| <b>Consultation Response from KC Lead Local Flood Authority</b>                                                                                              |                                                    |                                             |
| <b>2018/92686 land adj, 127, Westgate, Heckmondwike, WF16 0EW</b>                                                                                            |                                                    |                                             |
| <b>Outline application for erection of retail (A1) and drive thru restaurant (A3) development and associated car parking, landscaping and infrastructure</b> |                                                    |                                             |
| <b>Date Responded:</b><br><b>12/2/2019</b>                                                                                                                   | <b>Responding Officer:</b><br><b>Paul Farndale</b> | <b>Responding Ref:</b><br><b>2018/92686</b> |

Title
Proposed Site Layout

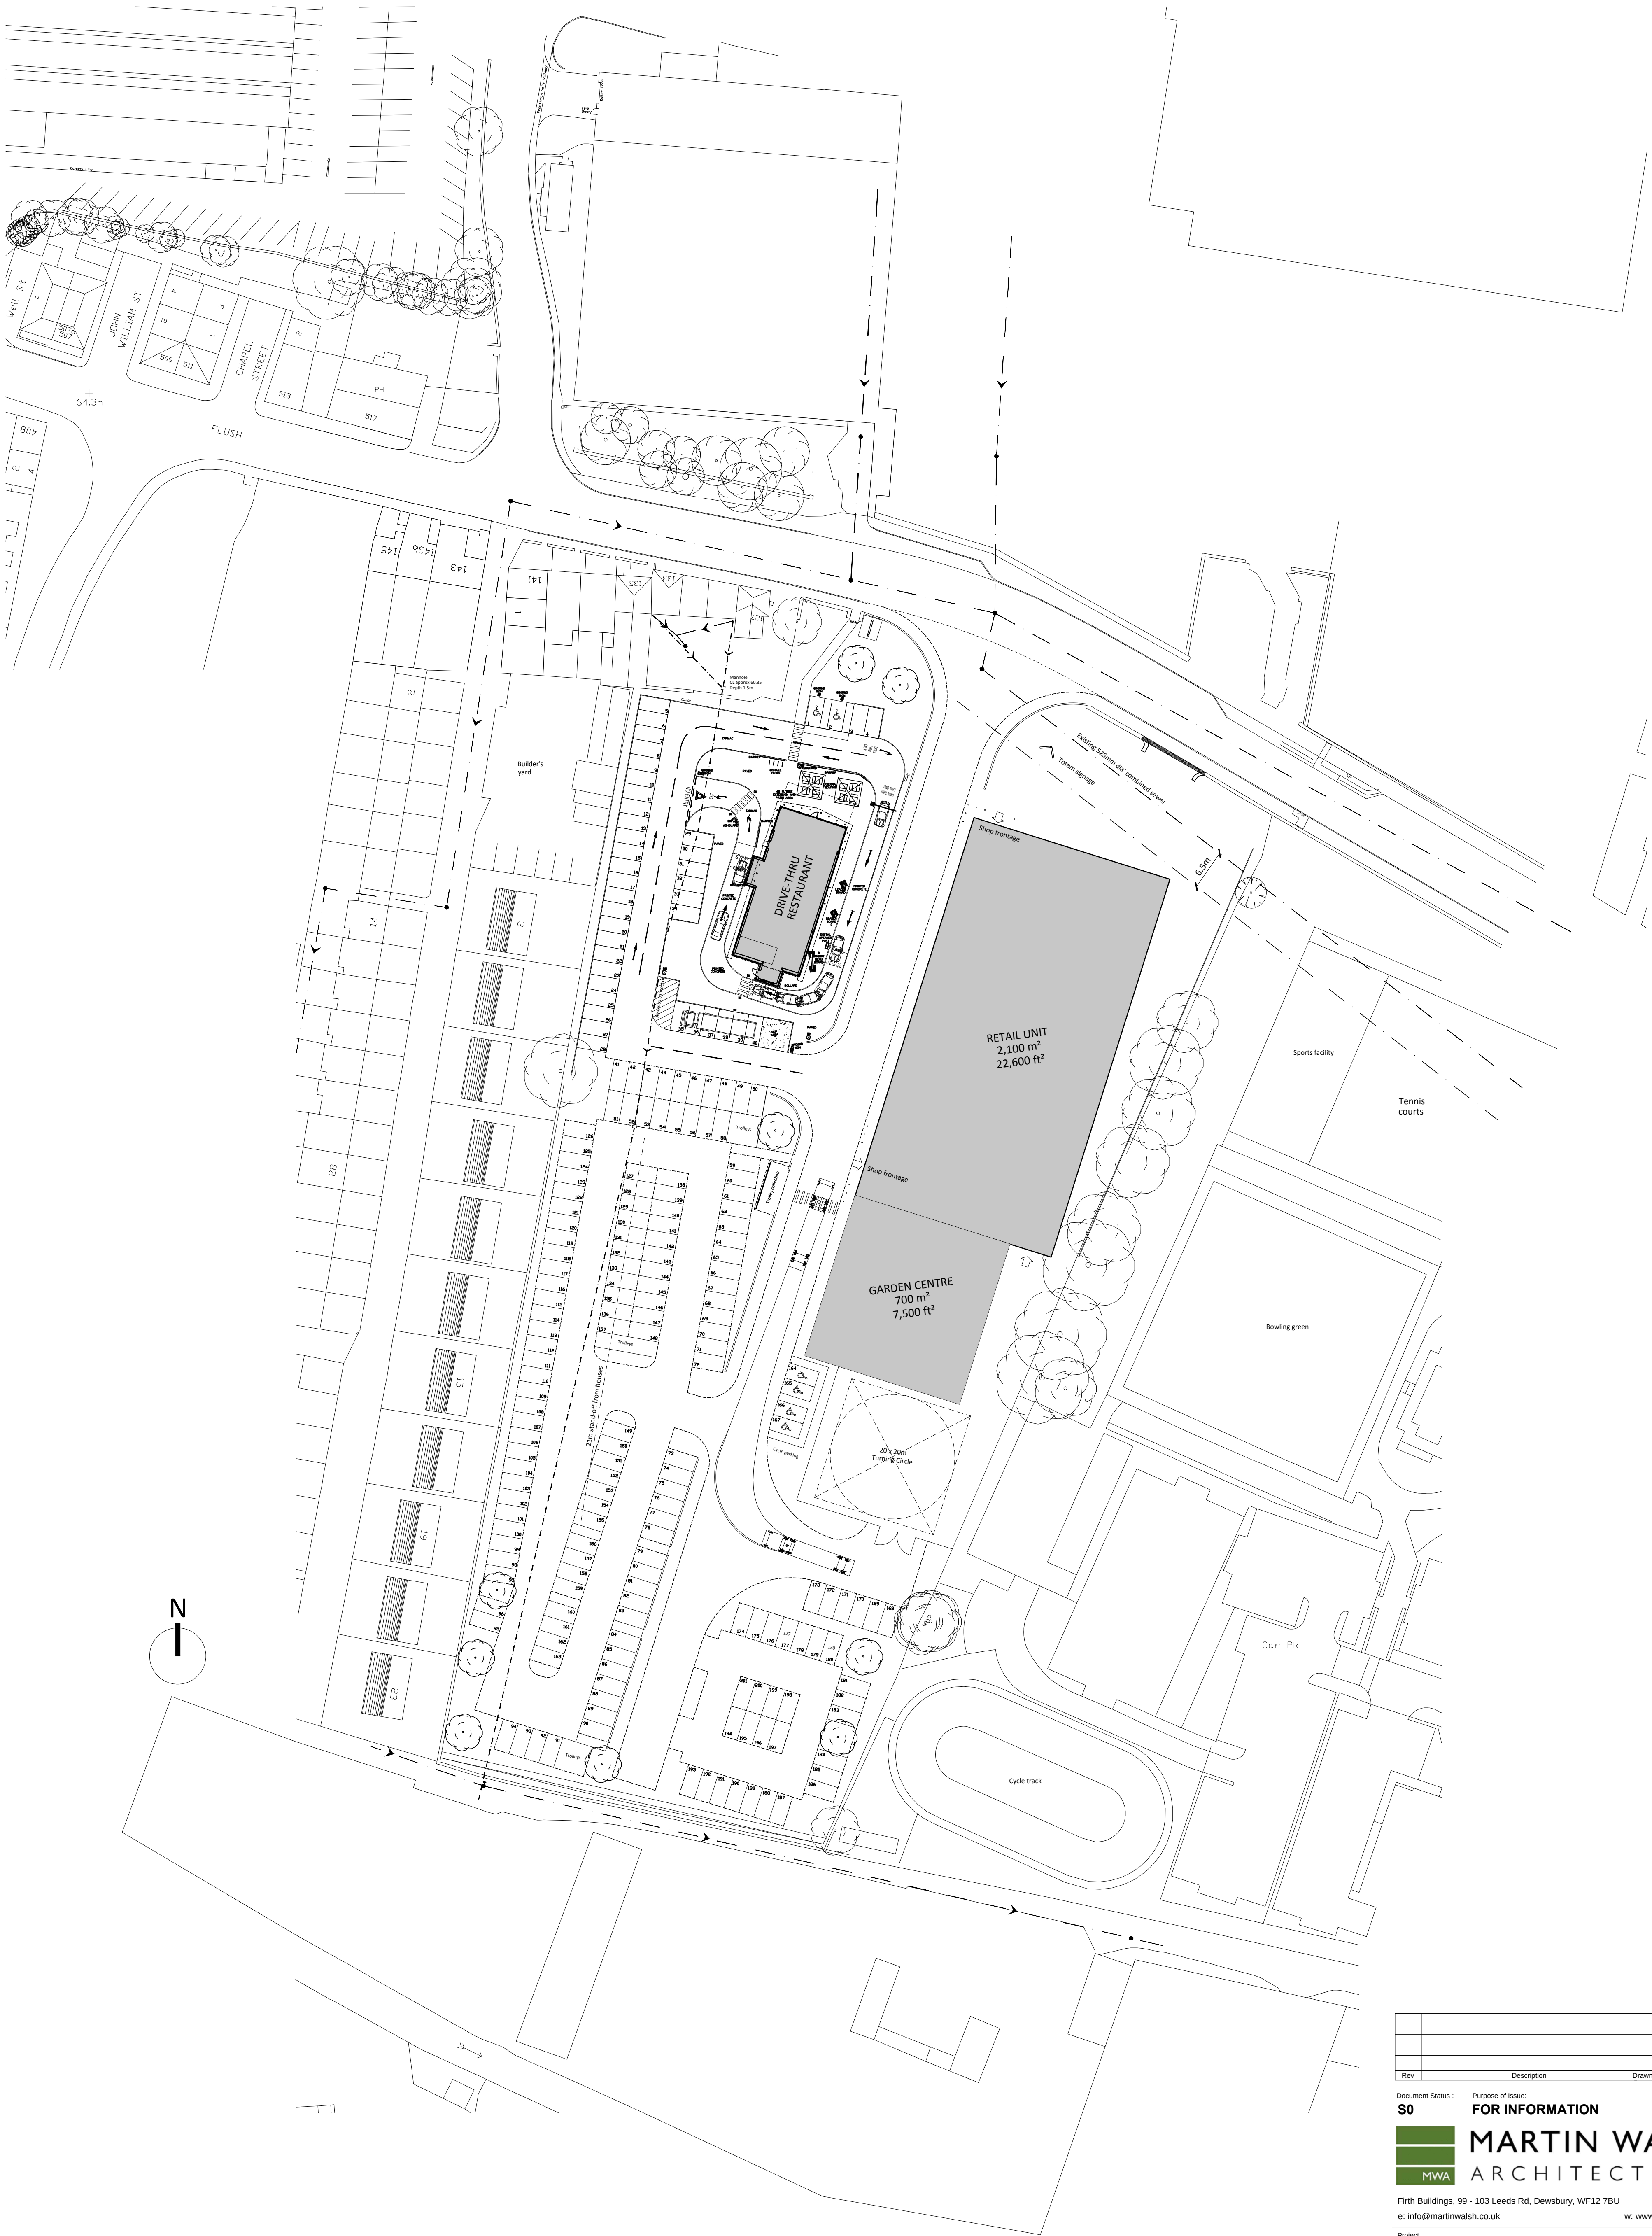
**Detailed response:** Further to our comments of December 2018 we point out that a diversion of the main culvert is shown. This should however minimise the angle of the bend to 45 degrees or less. We believe this can be achieved.

A second culvert is shown only in part but must be maintained. Renewal may be required but it is shown within 4 metres of the proposed building. A diversion plan is required here and could amalgamate into a single increase sized pipe.

We have previously stated that if there is escape from these systems above or within site, safe overland flood routes should be established. It is not clear if levels can be established in the parking areas in front of the entrance to clearly steer overland flows arounds the building. Flood risk mitigation has not been demonstrated in this instance.
